SPR EA1N and EA2 PROJECTS

DEADLINE 4 - COMMENTS ON APPLICANTS DEADLINE 3 SUBMISSIONS (CONSTRUCTION ISSUES)

Interested Party: SASES PINS Refs: 20024106 & 20024110

Date: 13 January 2021

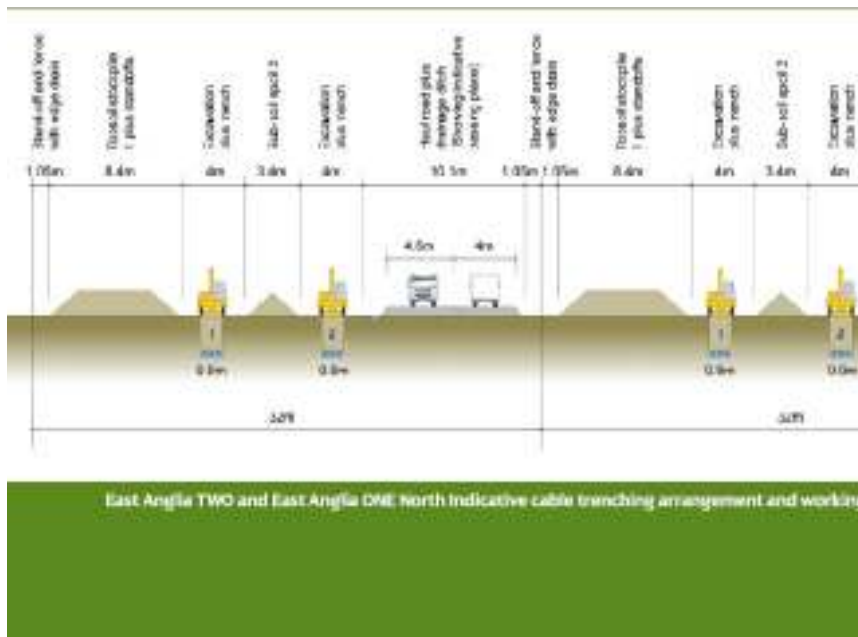
3. This document has omitted to clarify the Applicants' purpose in, or the necessity for, building two separate haul roads if Scenario 1 (EA1N and EA2 constructed concurrently) as illustrated by SPR – see below.
